**KIRKLEES METROPOLITAN COUNCIL
INVESTMENT & REGENERATION SERVICE**

Reference No:	2023/62/93735/E
Site Address:	41, Batley Field Hill, Upper Batley, Batley, WF17 0BE
Description:	Erection of outbuilding and erection of extensions and alterations to existing dwelling
Recommending Officer:	Jennifer Booth

DECISION - REFUSED

OFFICER REPORT

Proposed Garden Building Floor Plan

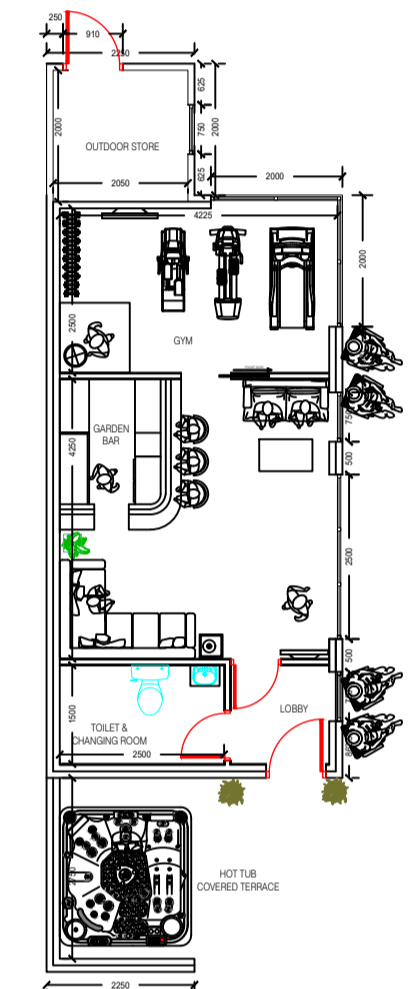
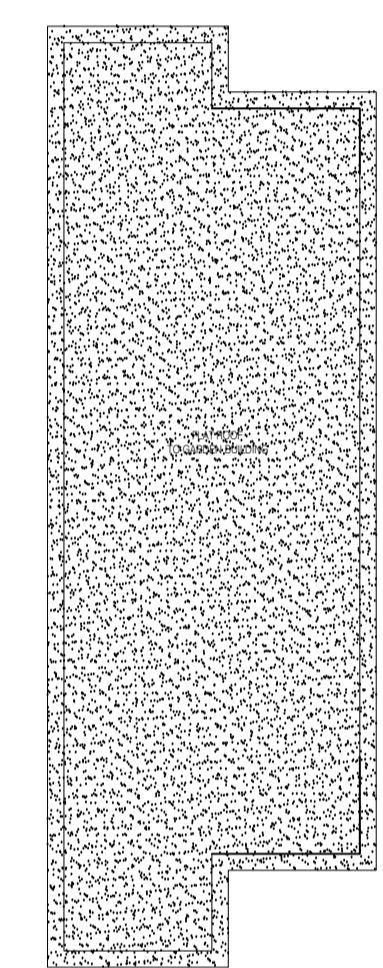
The detached garden building has the main block with the depth of 5m and a width of 9 for the main part which would house the shower room, bbq & bar and the gym. The hot tub enclosure would add further 2.8m by 2.5m, open fronted into the garden area. The store element on the other side of the gym would add 2.2m by 2.2m towards the garden. This would have a combination of render and glazing with a flat roof form.

The detached garden building would have limited impact on the heritage asset given the single storey nature, position to the rear of the property and limited footprint relative to the host property.

The outbuilding is to the rear with a limited height given the single storey nature, appropriate footprint relative to the host property and its associated curtilage and would be constructed using matching materials. As such, this element of the scheme is considered to be acceptable in terms of visual amenity.

Proposed First Floor Plan

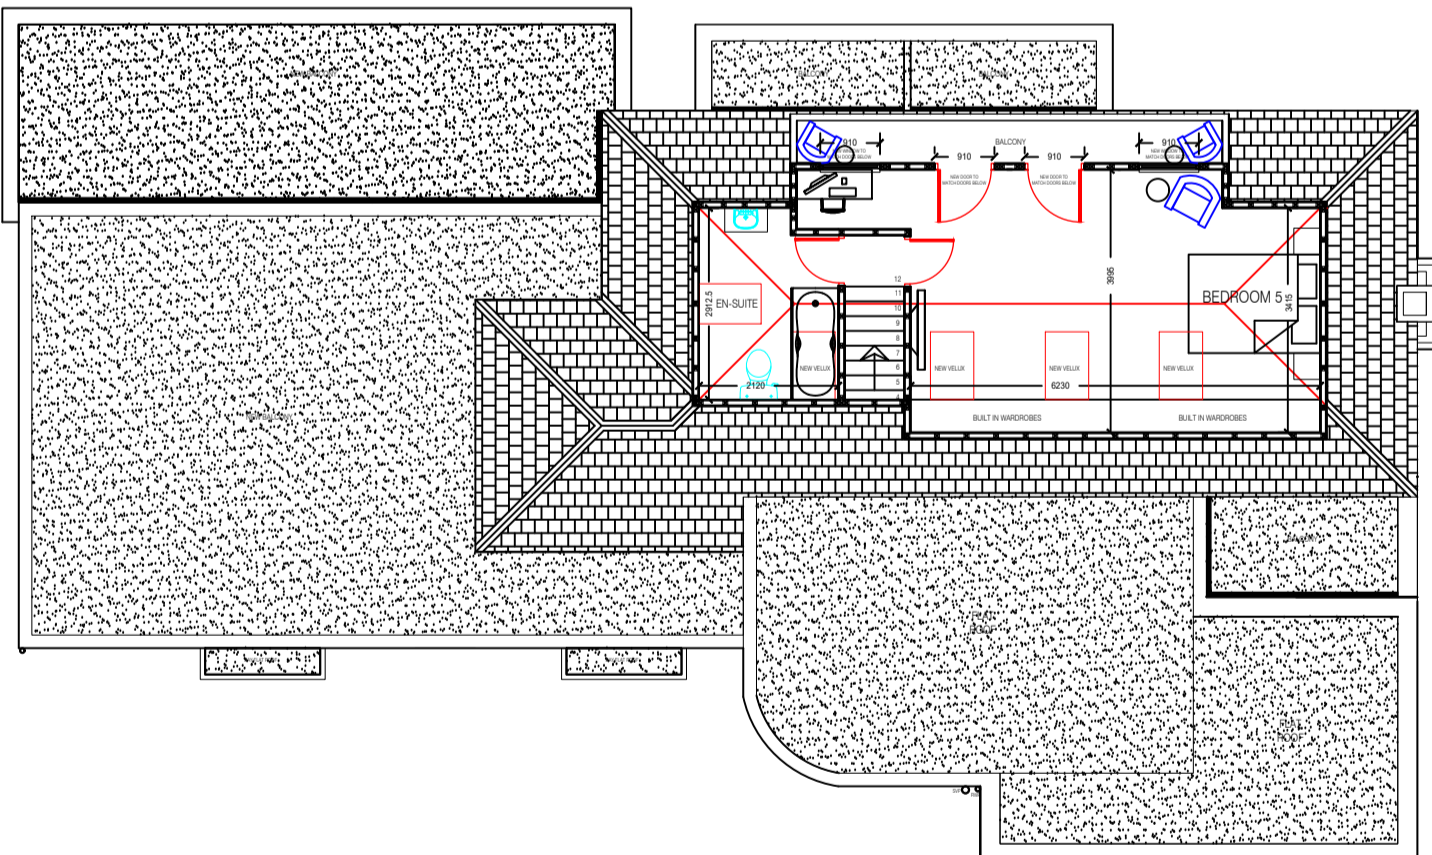
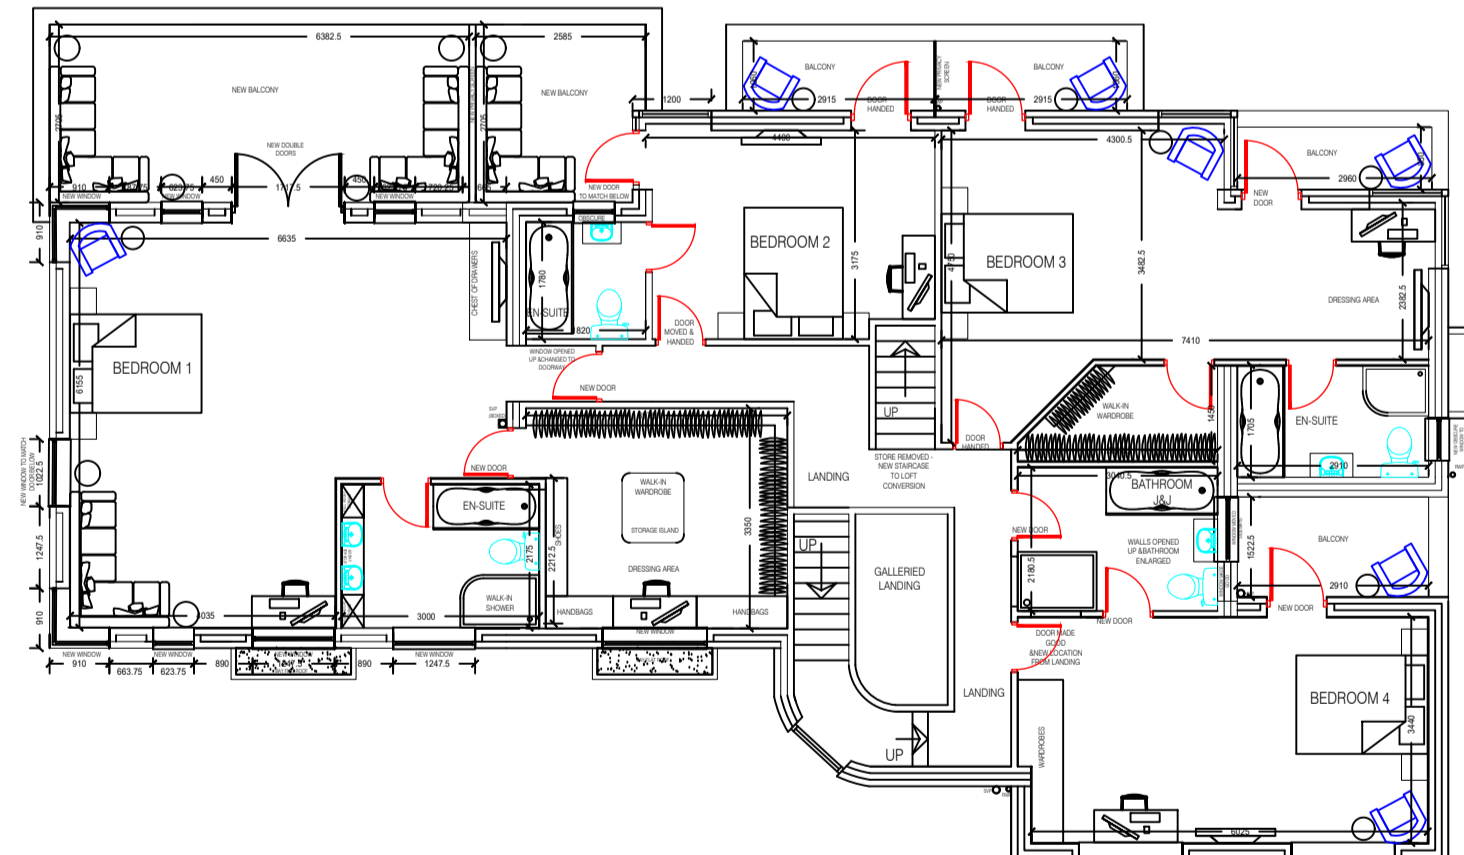
The adjacent property to the south west occupies a position some 5m from the host property. The extension proposed to the side would not reduce this space between the properties and would result in limited impact in terms of overbearing or overshadowing. However, the plans include a balcony which would overlook the neighbouring property.

The proposed south west side extension, in particular the proposed balcony would result in an unacceptable degree of overlooking and loss of privacy relative to the adjacent 39 Batley Field Hill. To permit the proposals would be contrary to Policy LP24 of the Kirklees Local Plan, KDP3 of the House Extensions & Alterations SPD and advice within Chapter 12 of the National Planning Policy Framework.

Proposed Rear Elevation ( East)

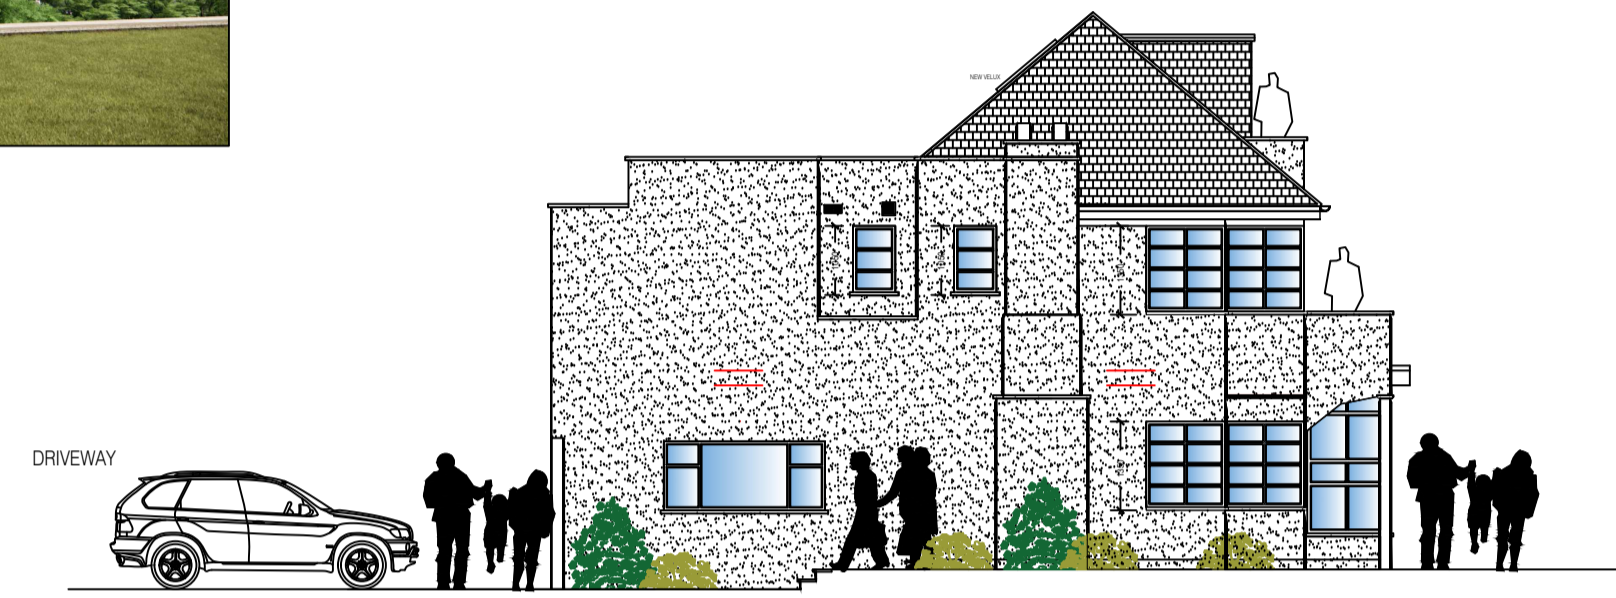
The rear dormer would have a width of 6.7m and a height of 2.4m with the balcony.

In this instance, whilst it is clear that the agent has tried to reflect some of the features of the property, the significant increase in terms of both side extensions with the extension on the north east side representing a very sizeable addition to the dwelling together with the large new roof to cover the original house and the south west side extension which will result in a significantly larger roof massing and the full size dormer at the rear would have a deleterious effect on much of the character of the property and would therefore be considered harmful to the heritage asset and fails to comply with Policy LP35 of the KLP and Chapter 16 of the NPPF.

1. The proposed extensions and alterations, due to the scale, design, mass and positioning result in a significant increase together with the large new roof to cover the original house and full-size dormer at the rear would significantly detract from the original scale and form of the host building harmful to the character of the non-designated heritage asset contrary to Policy LP35 of the Kirklees Local Plan and Chapter 16 of the National Planning Policy Framework.

3. The proposed south west side extension, in particular the proposed balcony would result in an unacceptable degree of overlooking and loss of privacy relative to the adjacent 39 Batley Field Hill. To permit the proposals would be contrary to Policy LP24 of the Kirklees Local Plan, KDP3 of the House Extensions & Alterations SPD and advice within Chapter 12 of the National Planning Policy Framework.

Proposed Front Elevation (West)

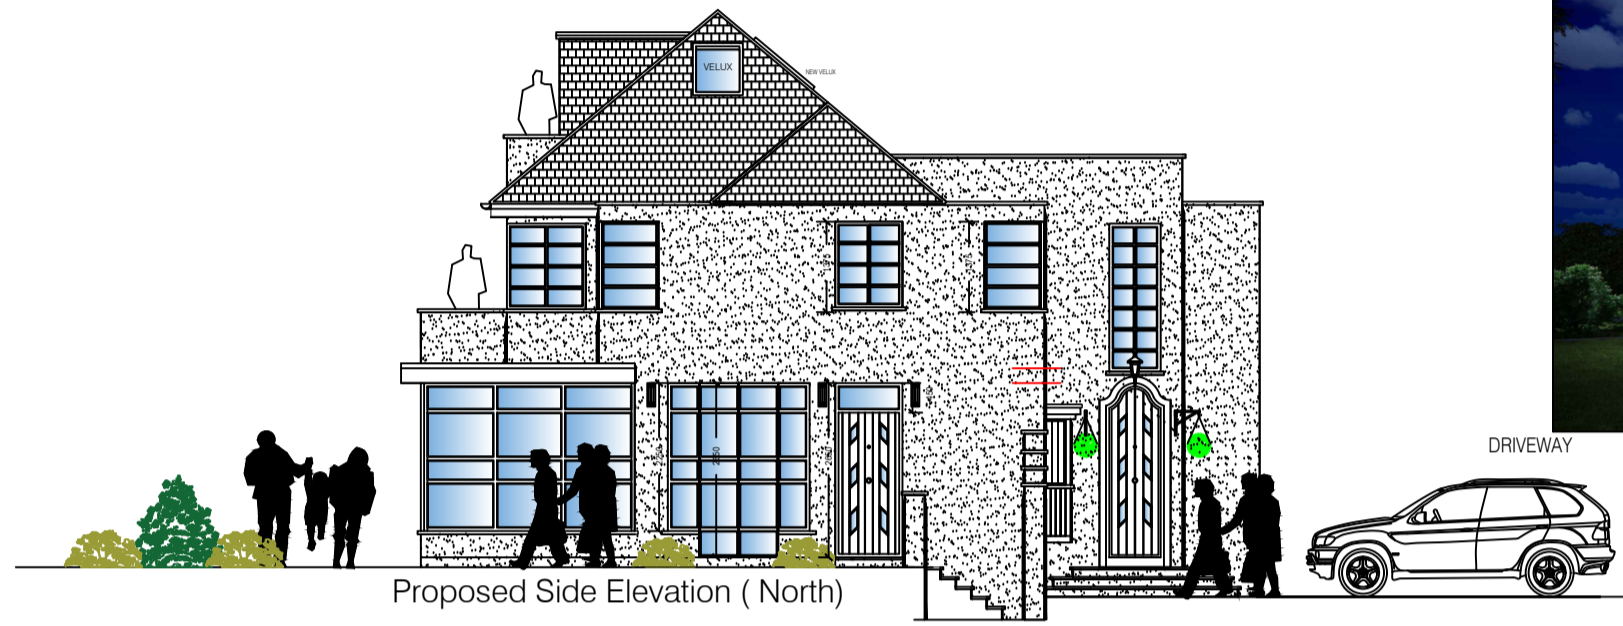
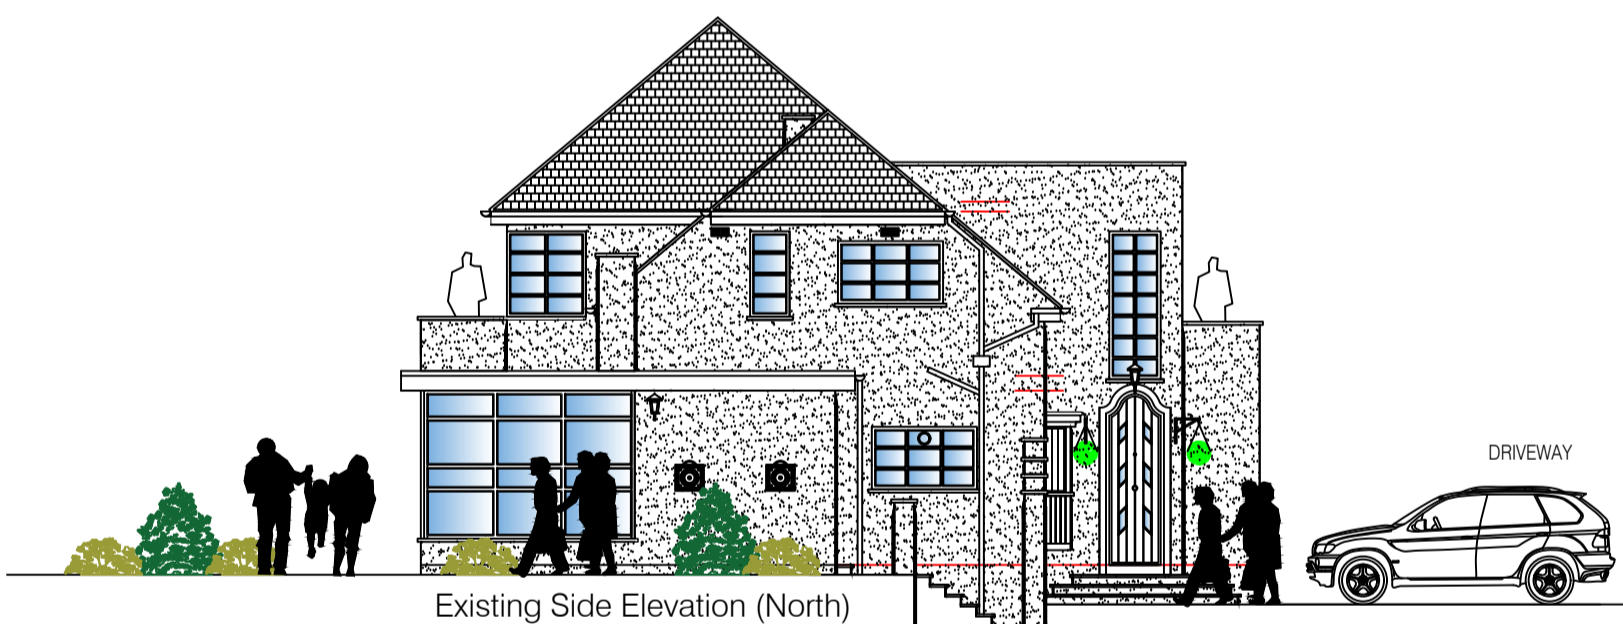
The two storey side extension with the flat roof form would project 7.2m from the original north east side, lying flush with the front of the dwelling and set back 1.2m from the main rear elevation. The new sunroom would project 3.2m from the rear of the side extension with a balcony formed above.

The side extension on the south west side would replace 1 of the garages, with a width of 3.2m and a depth of 10.2 with a 1m balcony formed on piers.

The scale of the extensions proposed to the sides of this property are significant & disproportionate to the main house and would not form subservient additions to the property. The scale would overwhelm the original house and is therefore not considered to be acceptable. It is appreciated that the continued use of white render would be in keeping with the aptly named White House. However, the design of the development, because the works are so large would not reflect the character of the host property and would obscure a number of the unique features of the art deco property. The scheme consists of extensions to both sides and to the roof at the rear, which form inappropriate design because of the sheer size which would not be in keeping with the dwelling and would form an incongruous and significantly harmful relationship within the surrounding area.

2. The proposed extensions and alterations, due to the scale, design, mass and positioning would detract from character of the host property obscuring existing unique features, forming an incongruous which would not appear subservient thereby significantly harmful to the host and surrounding area . To permit the proposals would be contrary to Policy LP24 of the Kirklees Local Plan, KDP1 & KDP2 of the House Extensions & Alterations SPD and advice within Chapter 12 of the National Planning Policy Framework.
